DECISION DELEGATED TO HEAD OF PLANNING

Application No: H22-0853-23 **Applicant:** George Hay & Sons Ltd

Proposal: Conversion of barn to single dwelling to include demolition of lean-to

Location: Agricultural Barn To The North Of Weston Barn House Marsh Road
Weston

Client George Hay & Sons Ltd		
Project Barn to the north of Weston Barn House Marsh Road, Spalding Marsh		
Drawing Proposed Site Plan		
Scale @ A3 1: 500		Date 19/09/23
Drawn By WW		Checked By LMS
Job Number 1154-2	Status PL	Purpose of Issue Planning

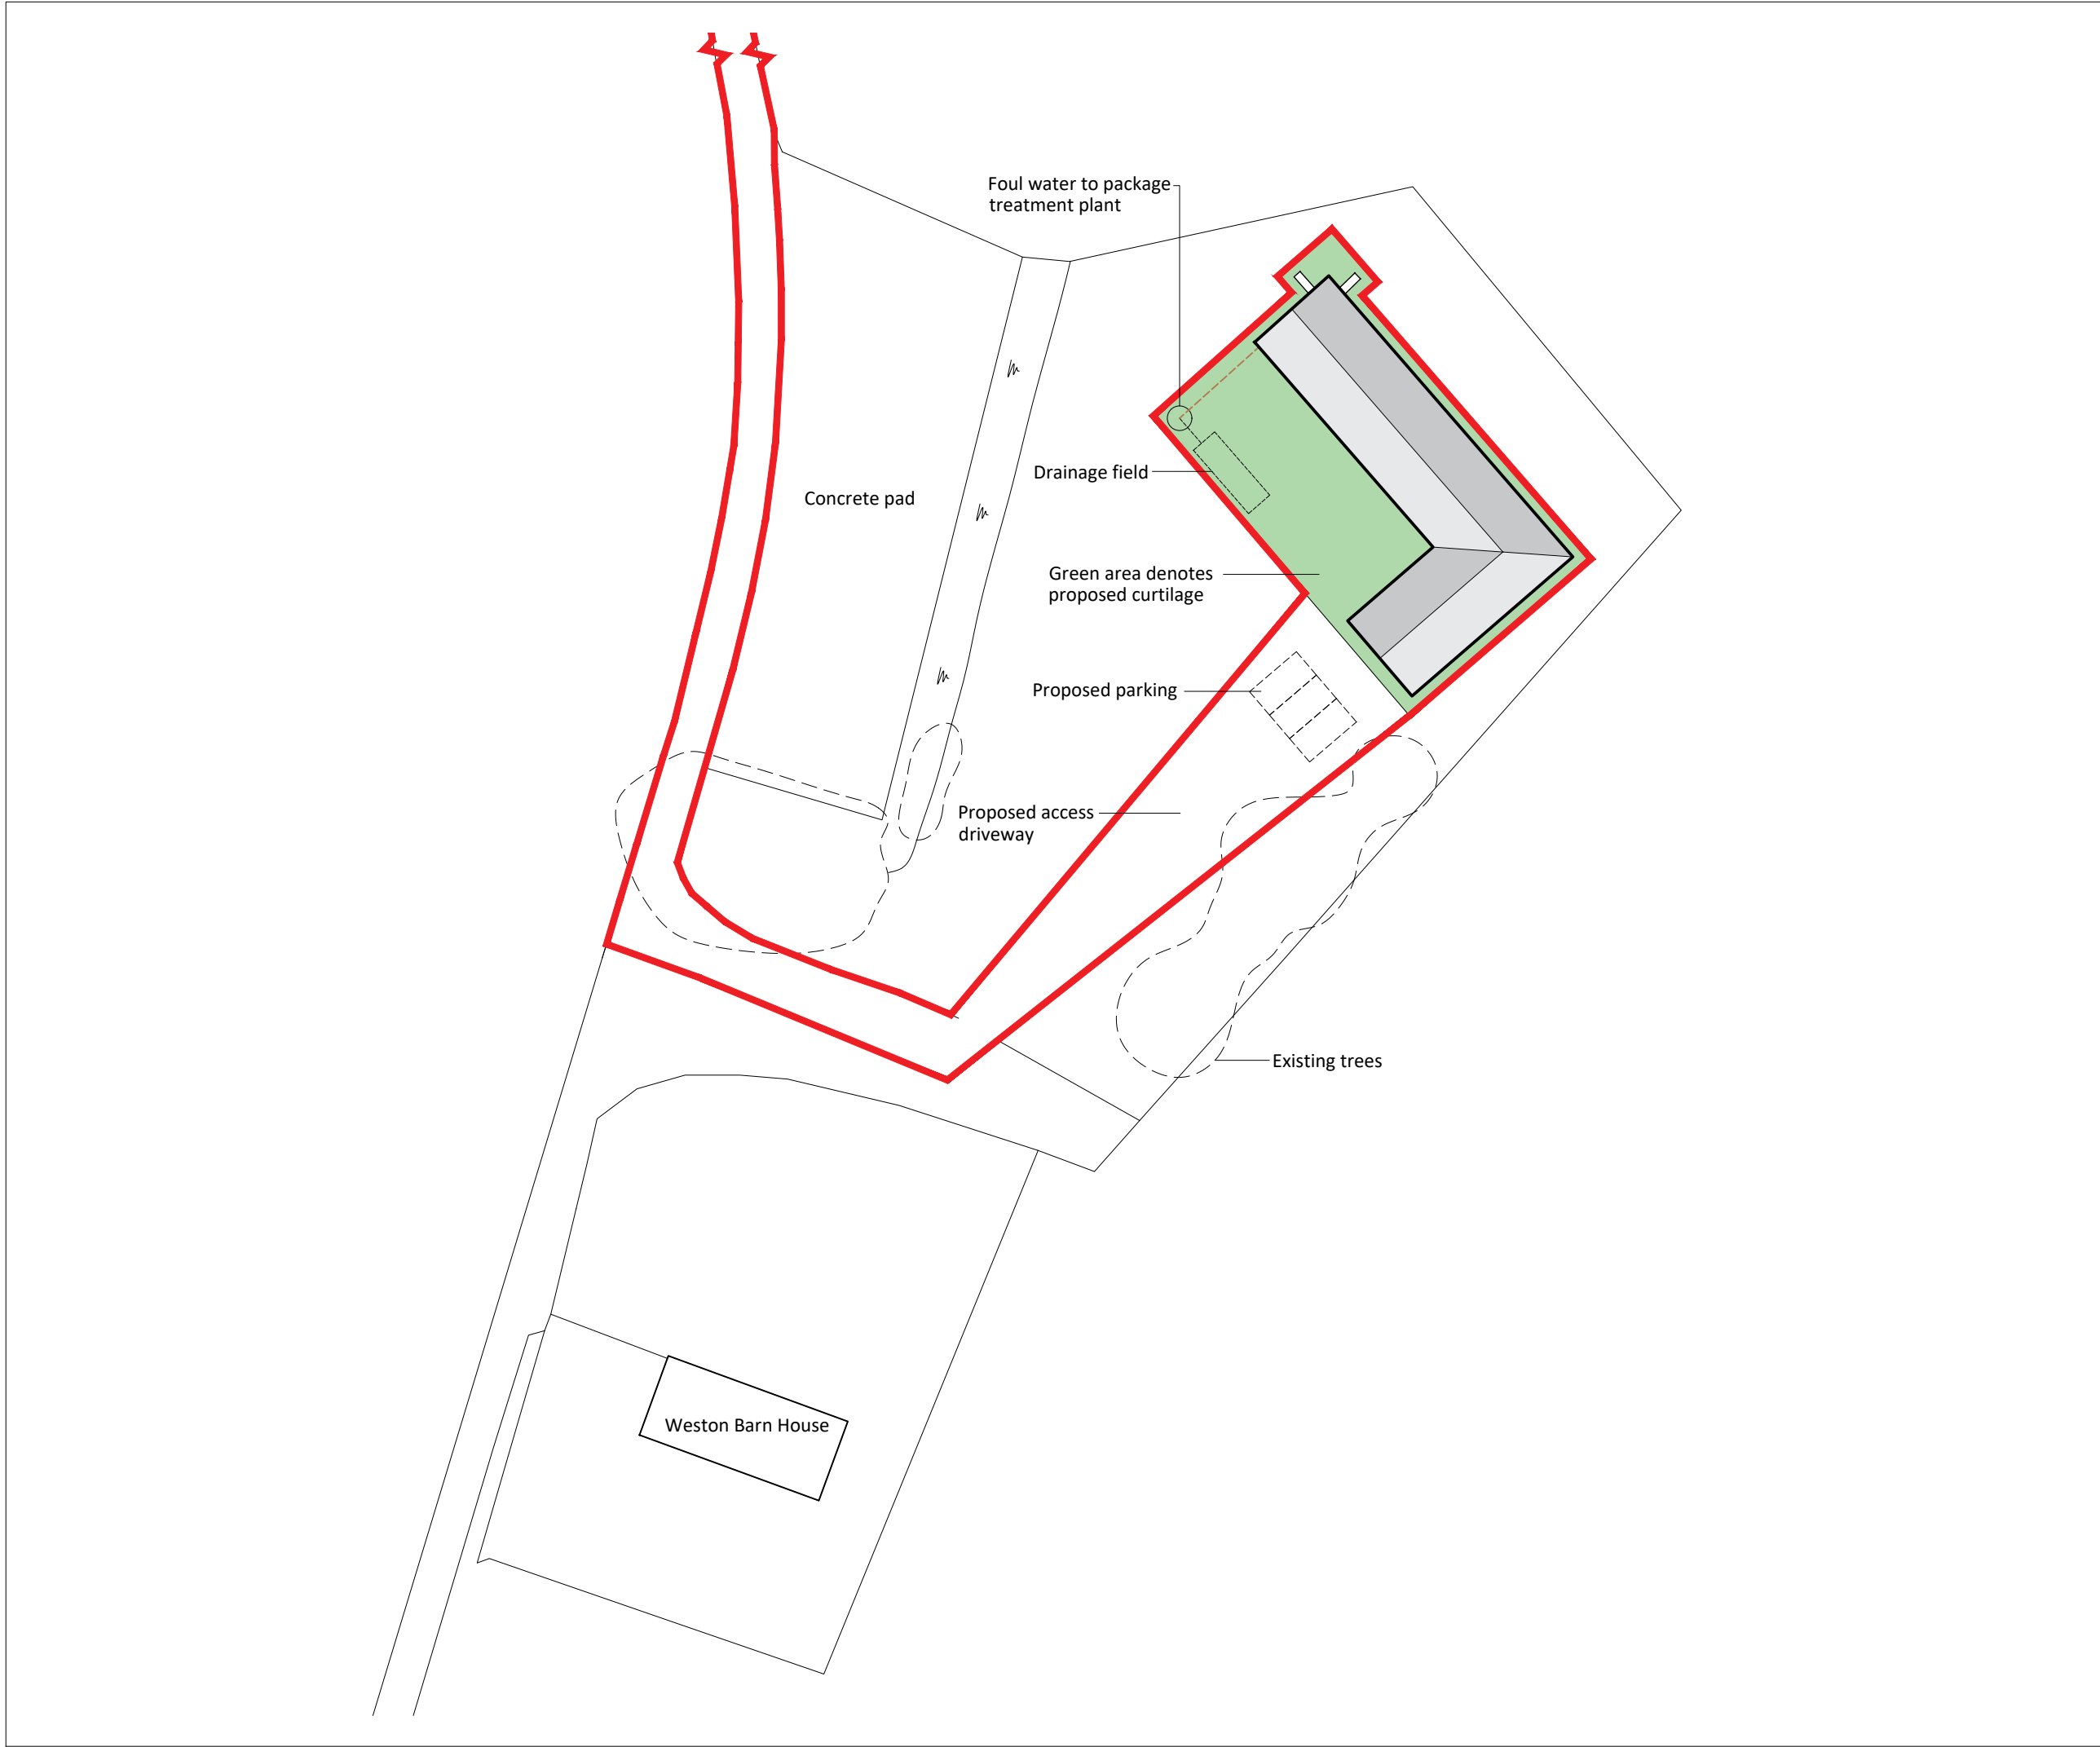
In consideration of the above and having given due regard to the appropriate local and national planning policy guidance (in particular the National Planning Policy Framework), Lincolnshire County Council (as Highway Authority and Lead Local Flood Authority) has concluded that the proposed development would not be expected to have an unacceptable impact upon highway safety or a severe residual cumulative impact upon the local highway network and therefore does not wish to object to this planning application. The following comments have been made by the Authority's Senior Countryside Officer; Moulton Public Footpath No. 2 and Weston Public Footpath No. 7 pass through the red development boundary which is earmarked for the driveway, although it is unclear if this will materially affect the public footpaths.

- The surface of the public footpath should not be disturbed without the permission of the highway authority.
- The legal alignment of the public footpath should remain open and available for public use. It is

expected that there will be no encroachment, either permanent or temporary, onto the right of way as a result of the proposal.

- No additional structures (i.e. gates) should be erected on the surface of the public footpath without the prior consent of the highway authority.
